**Consultation Response from KC,
Lead Local Flood Authority**

2020/93954 Land at, Lingards Road, Slaithwaite, Huddersfield, HD7 5HY

Erection of 43 dwellings and associated works

Date Responded: 30th November 2022

Project HOUSING AT LINGARDS RD SLAITWAITE
 Client SB HOMES LTD
 Drawing SITE SECTIONS ACROSS LINGARDS RD
 Scale 1:200
 Dwg No 2019 572 61

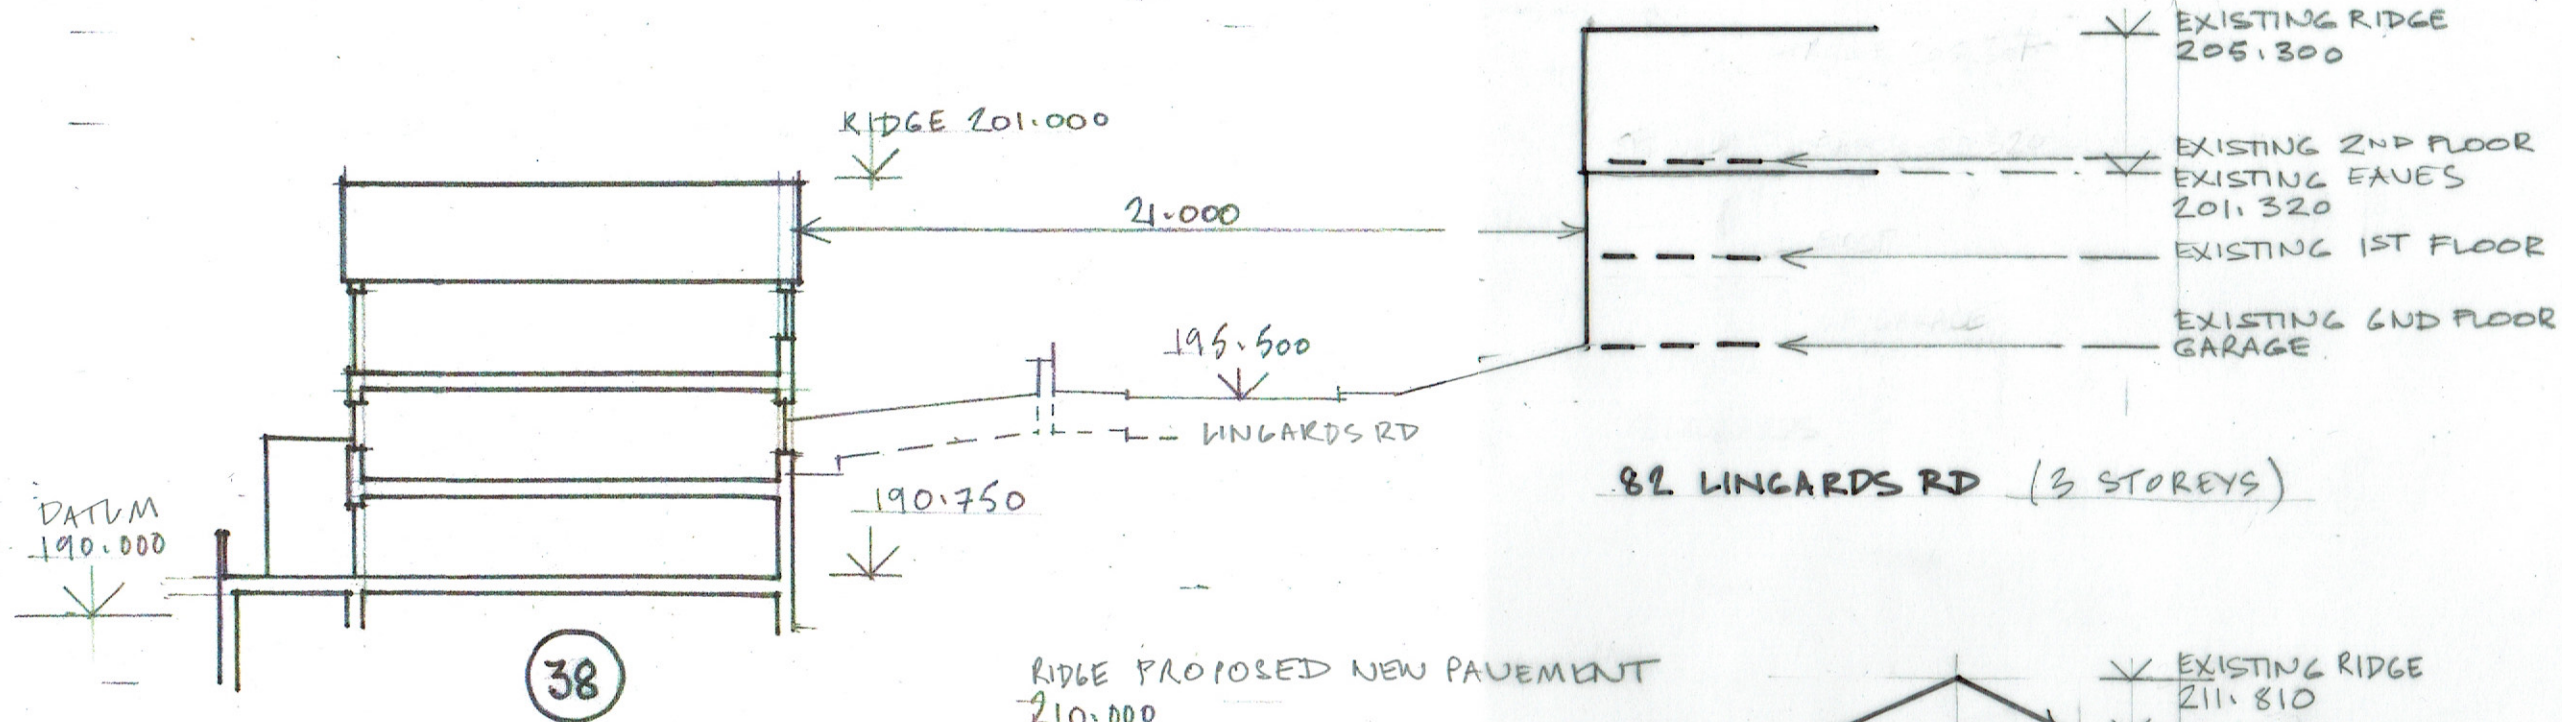
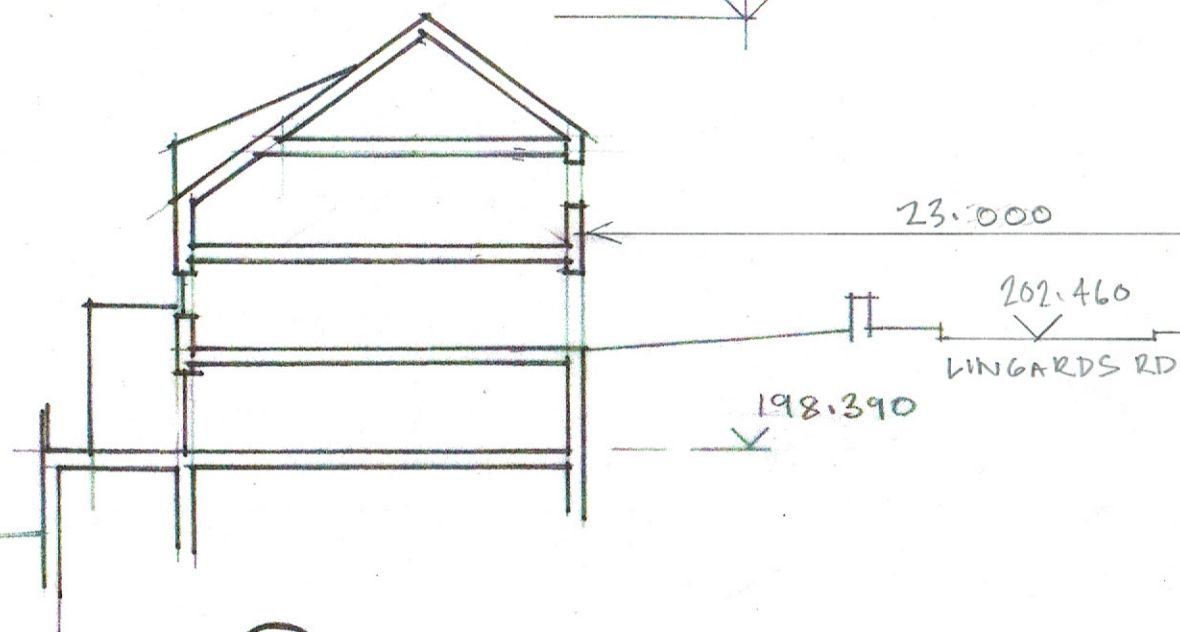
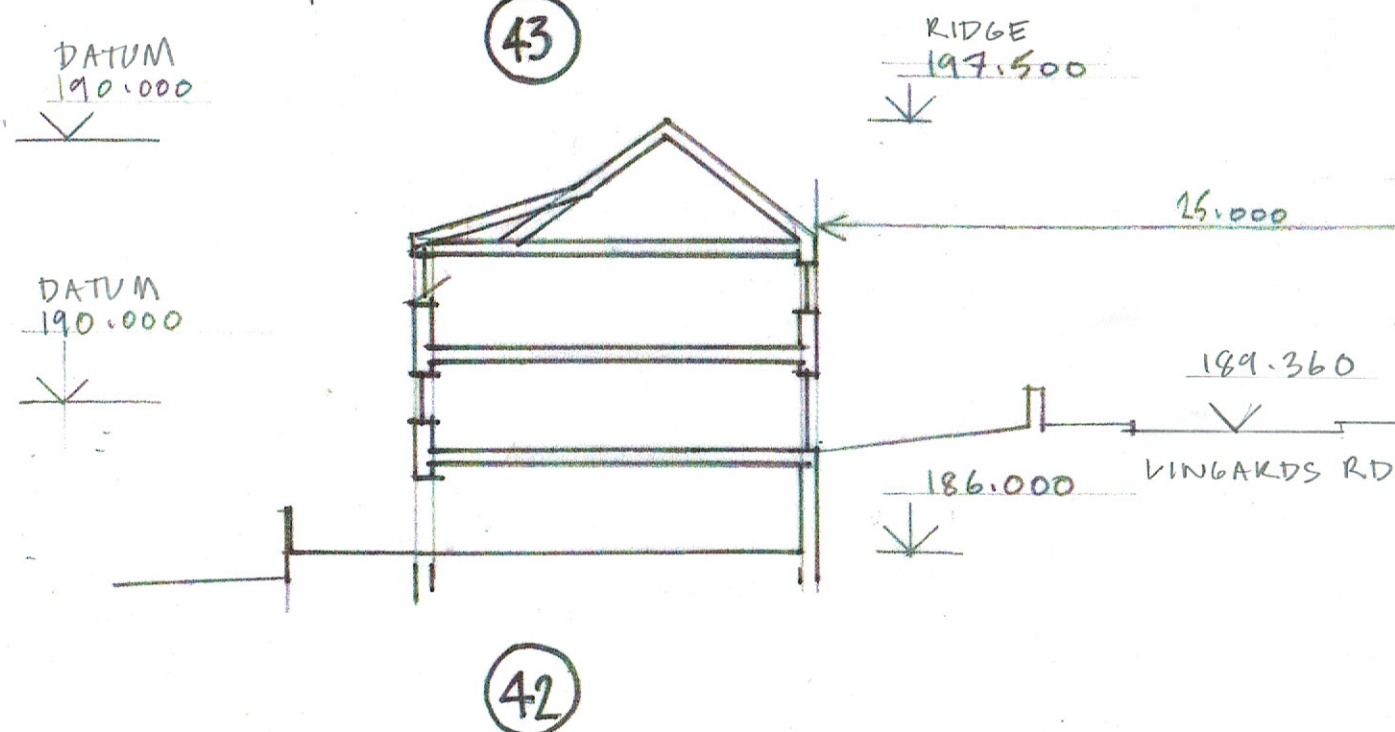
Further analysis of risk to plots fronting to Lingards Road should be clearly presented to ensure these proposed properties are not affected by flood risk.
